From: Natalie McKellar [REDACTED]
Sent: 11 July 2022 14:16
To: Jessica Riches
Cc: Office
Subject: FW: Ryefields: AL/31/22/PL
Attachments: Appeal Decsion.pdf; Site Layout.pdf

From: Jessica Riches <jessica.riches@arun.gov.uk>
Sent: 07 July 2022 16:41
To: Kerry Simmon [REDACTED]
Cc: Edward Rees [REDACTED]
Subject: Ryefields: AL/31/22/PL

VISIBILITY SPLAYS AT ACCESS
2M X 23M AND 2M X 15M

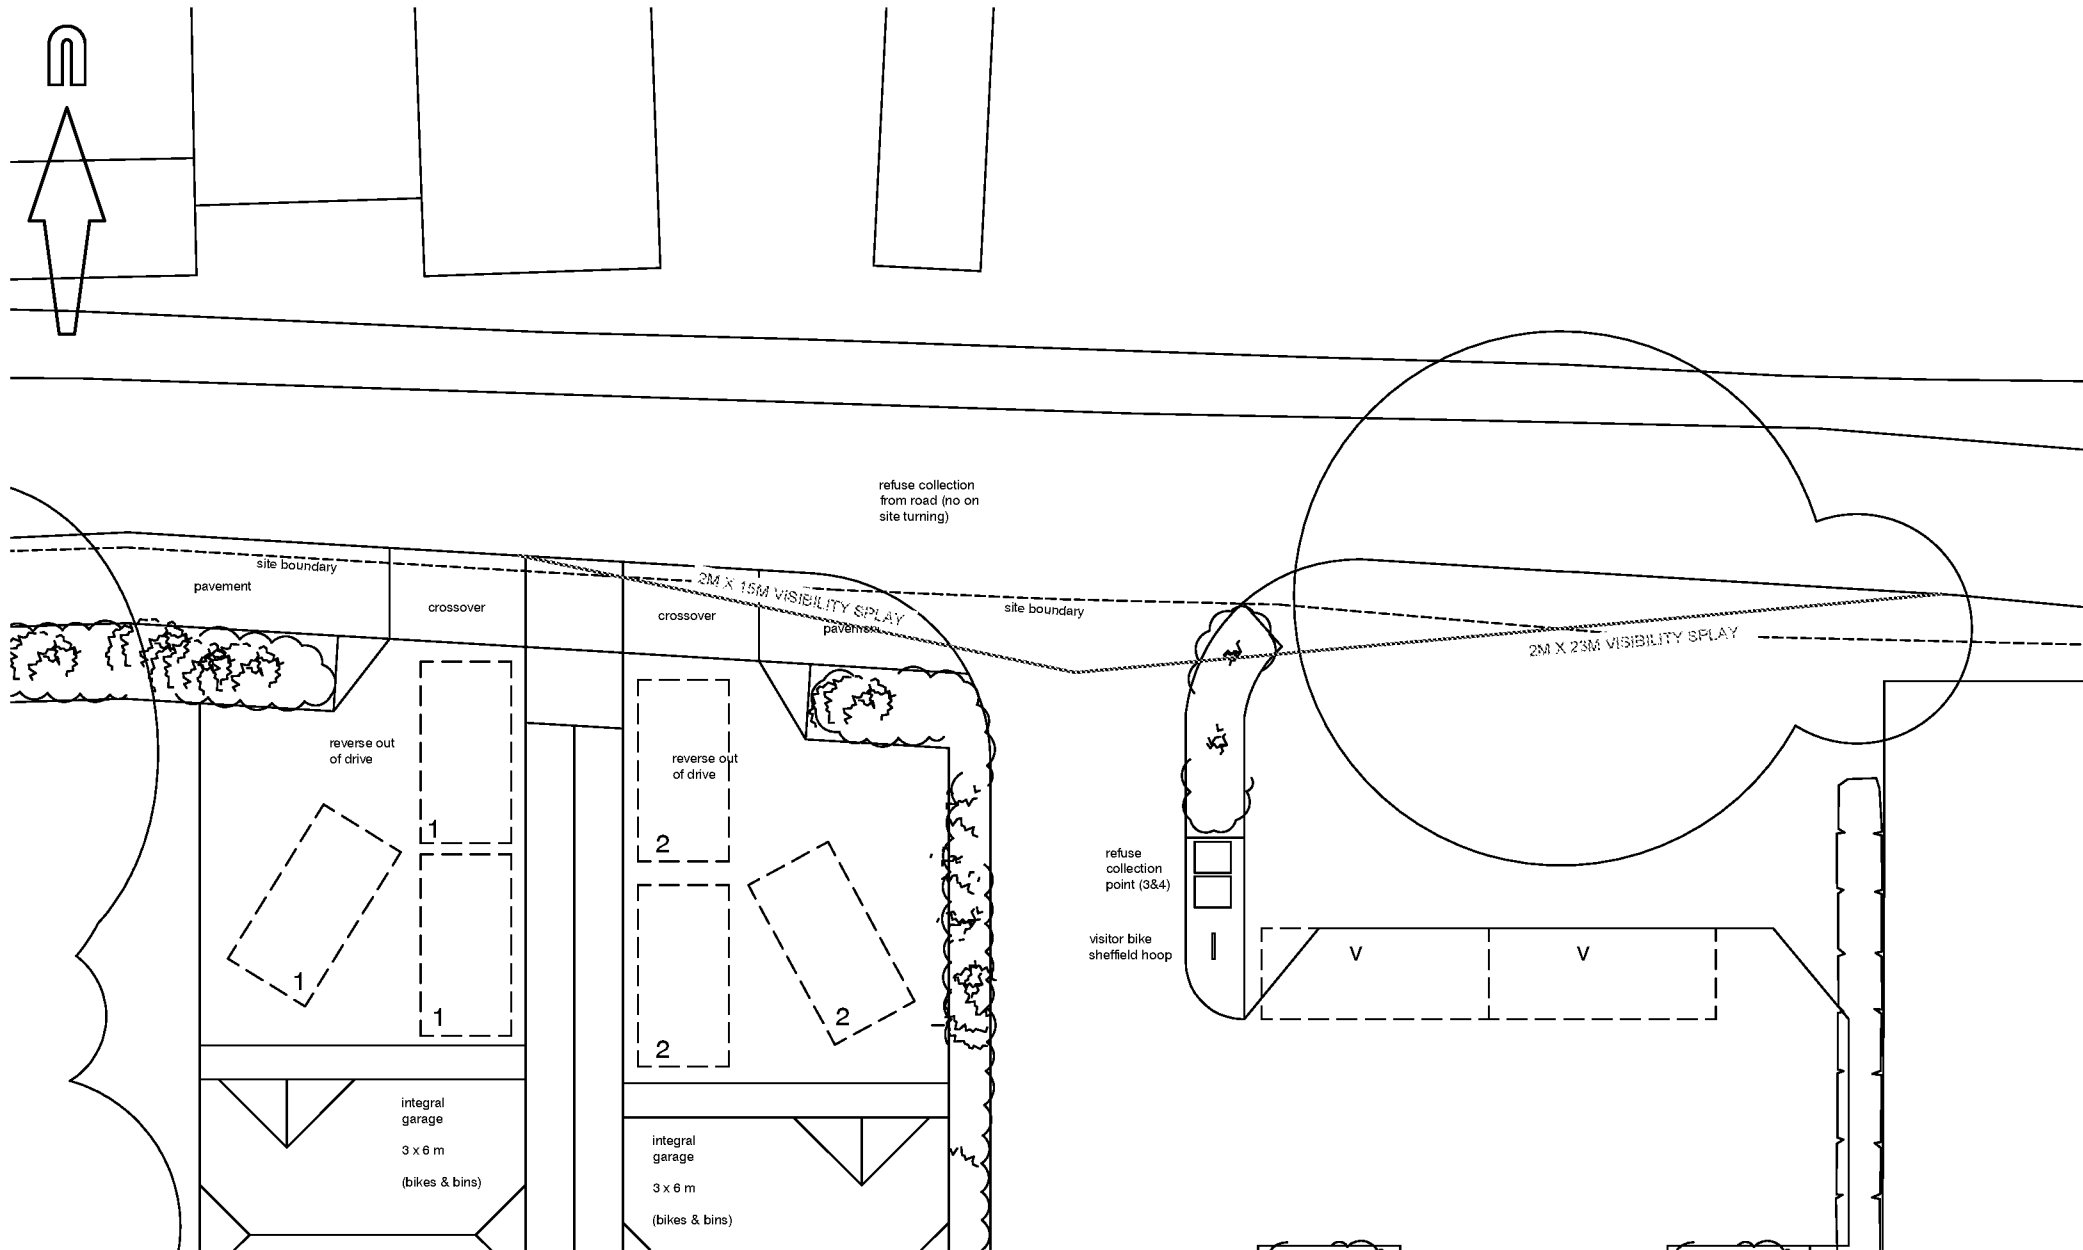
I think the proposed layout still presents some issues, especially with the access points and visibility splays showing that the T15 tree may interfere and be at risk of clearance. Therefore, it is recommended that you explore the site with two pairs of semi-detached houses, with access for plots 3 & 4 shifting to the west of the site to ensure the retention of T15. As a result, plot 1 would become slightly smaller as a 3-bedroom dwelling, and plot 2 moves further to the west to accommodate the shifted access.

In terms of the plans submitted, we would be expecting fully revised plans, which would include revising any arboricultural statements and retention plans based on any new layouts. Additionally, we would need a plan which more accurately details that the access works will not impinge on the retention of the protected tree (T15).

Figure 4: Proposed site plan

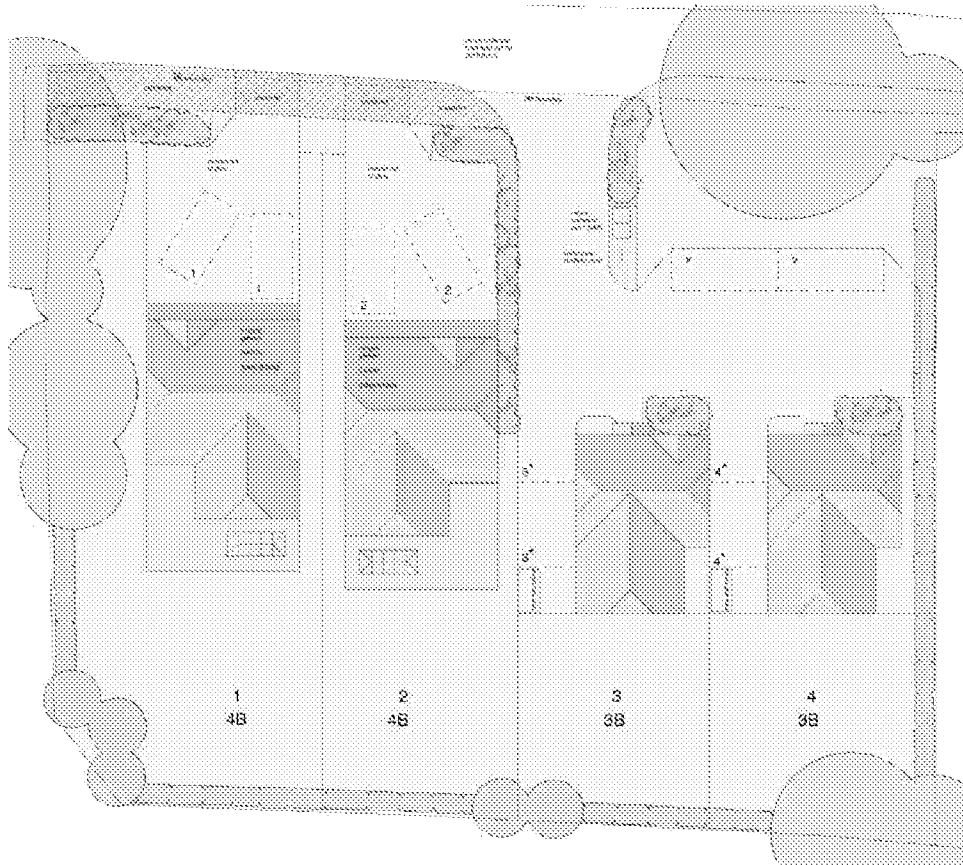
Plot 1 & Plot 2, which has been turned into a three bedroom requires 2 on plot car parking spaces each. I think with two pairs of semi-detached houses, you may wish to look at how to better incorporate parking within the scheme, and ultimately remove the integral garage from the 3 beds to provide a better ground floor living environment. Plot 2 parking could become tandem and located to the side of the dwelling to allow the shared driveway for plots 3 & 4.

In terms of BNG, I appreciate the provision of some additional trees and other vegetation incorporated into the development, however only 4 new trees are proposed whilst 5 are proposed to be removed. I think this could be improved, particularly to the east boundary of the plots.

1. We are committed to working with the LPA in order to prepare a scheme that is capable of achieving officer support, and we are looking at the layout changes set out in your email with the understanding that we will provide revised drawings to you on or before the 29th July 2022.

3. In terms of your design and layout requests, we are confident we can address these, however in terms of our position on the extended pedestrian walkway we have the following comments:
